Mr Des Surleff
Manager
COMMERCIAL TOWER 3
300 BARANGAROO AVENUE
BARANGAROO NSW 2000

**Sydney Metro Victoria Cross OSD
Stage 2 (SSD-10294) & Stage 1 Modification (SSD-8874-Mod-1)**

ATTACHMENT A

DESIGN REVIEW PANEL PRESENTATION
MILLER STREET ARTICULATION ZONE
FEBRUARY 18TH 2020

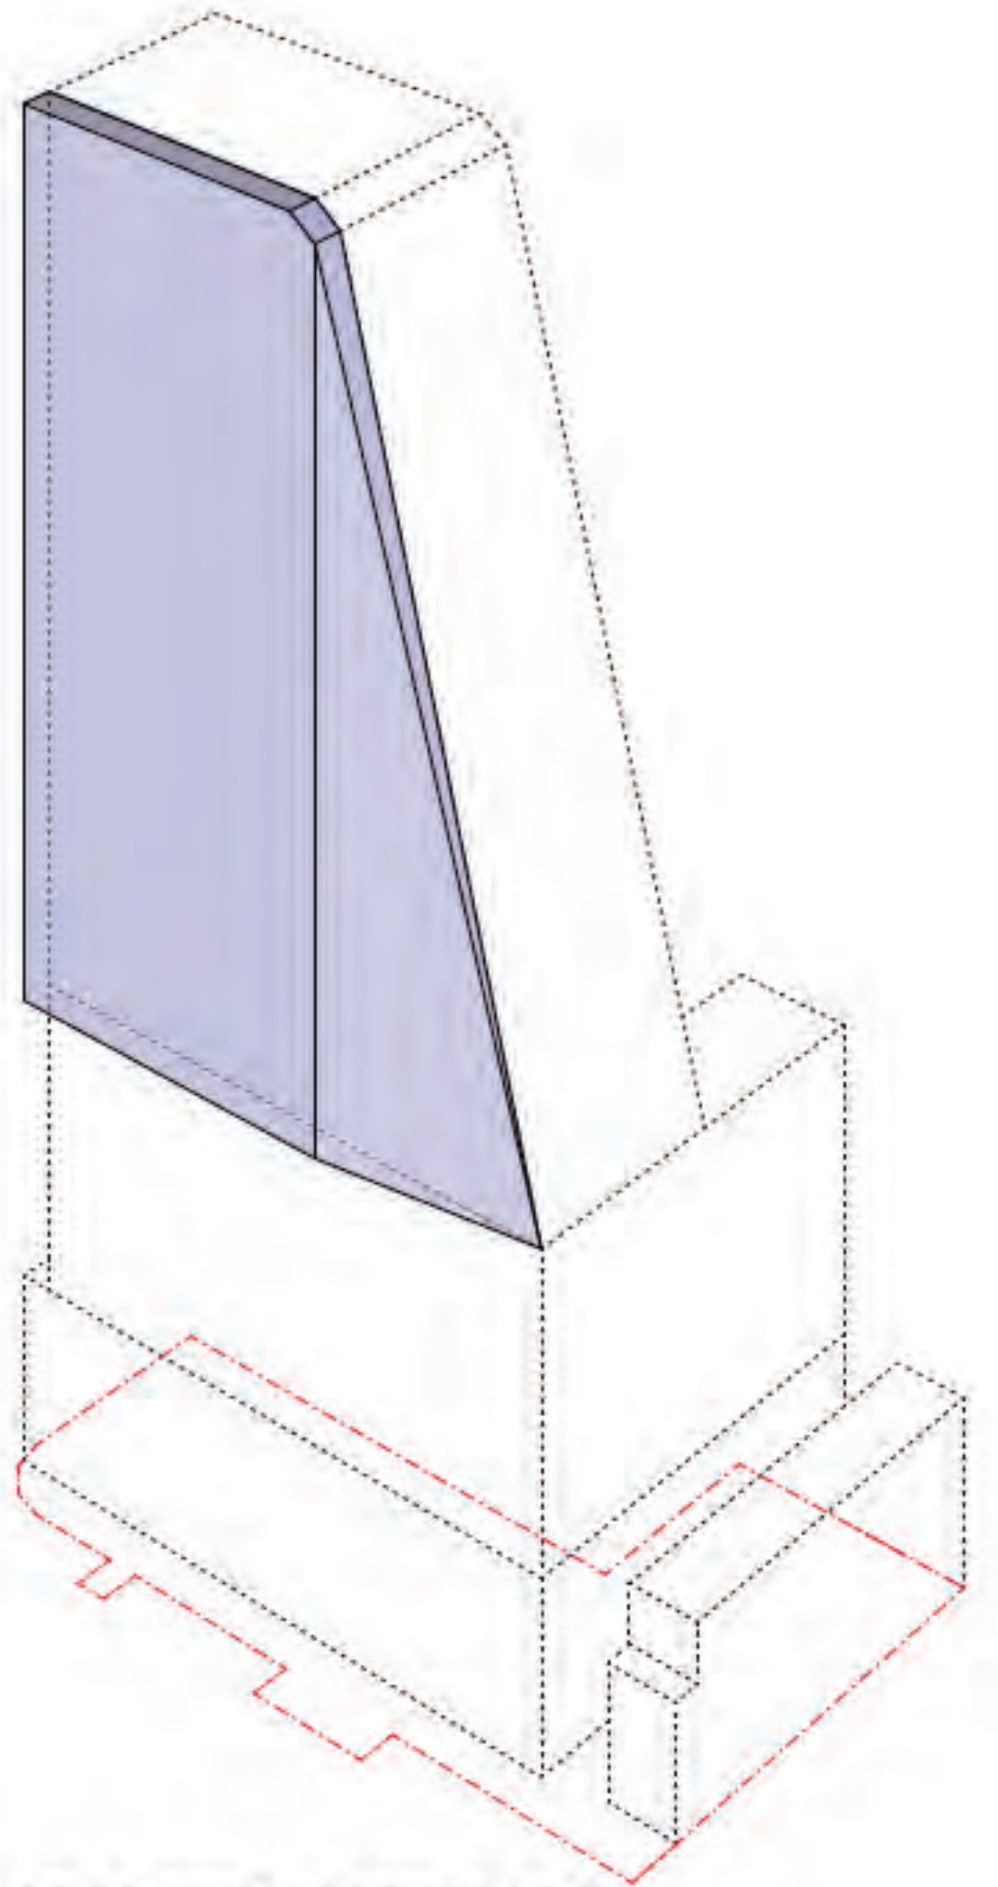
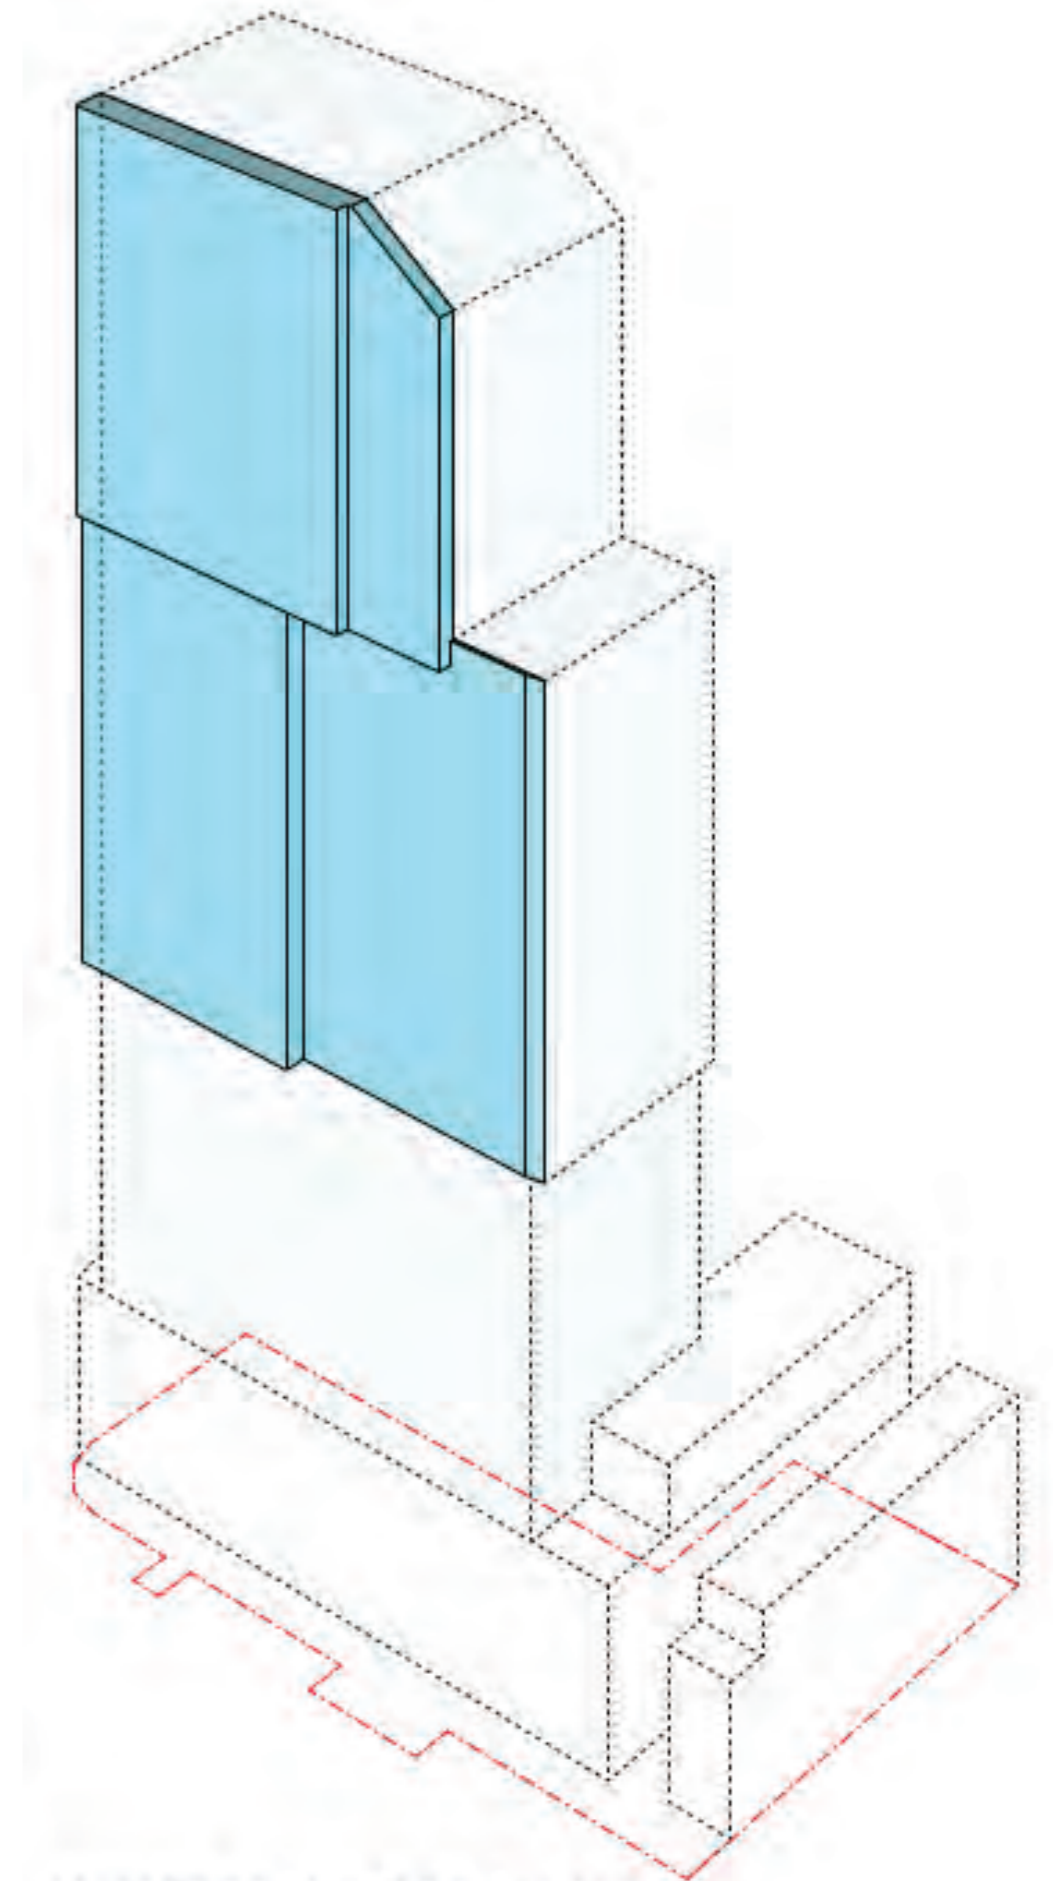
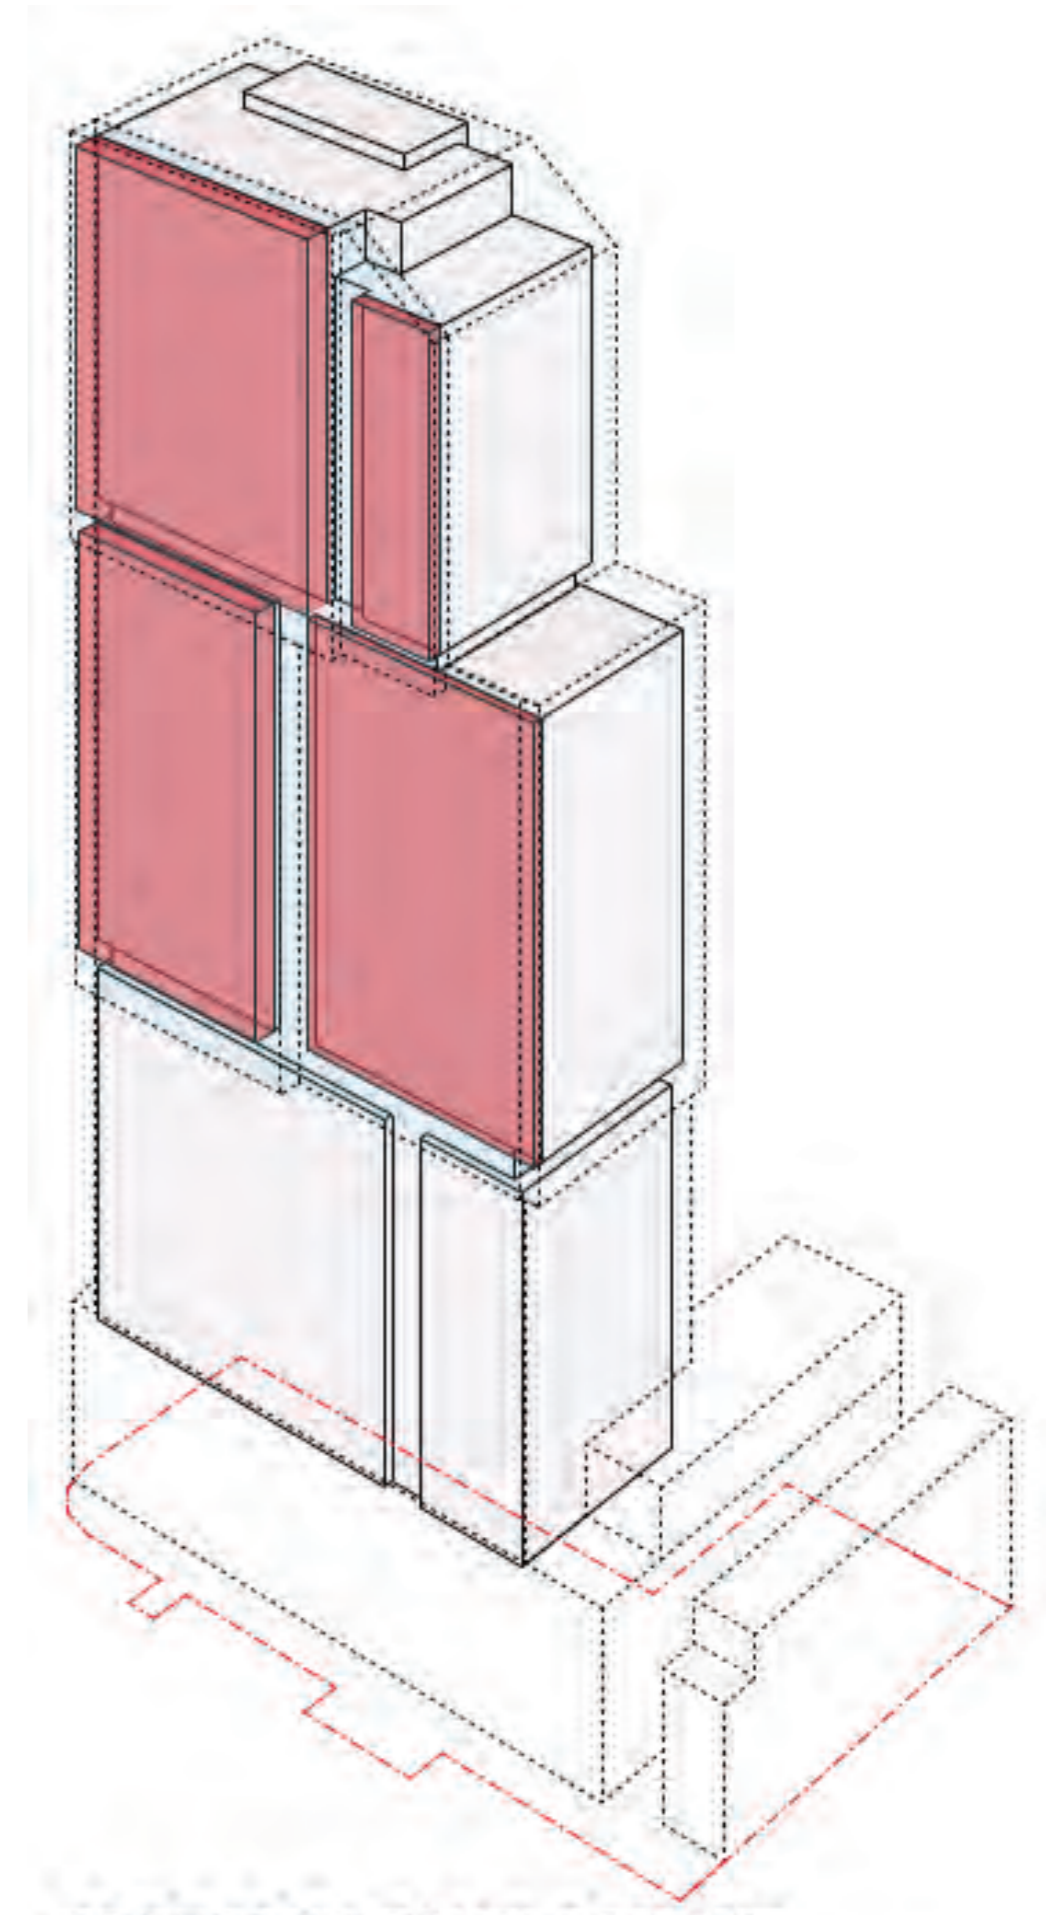
- a) the design of the tower within the articulation zone and how the specific design criteria in the approved Design Guidelines have been addressed
- b) the proposed modifications to the building envelope and distribution of massing in relation to the view loss and amenity concerns raised in public submissions
- c) Condition A15 which requires the building not to exceed the approved building envelope.
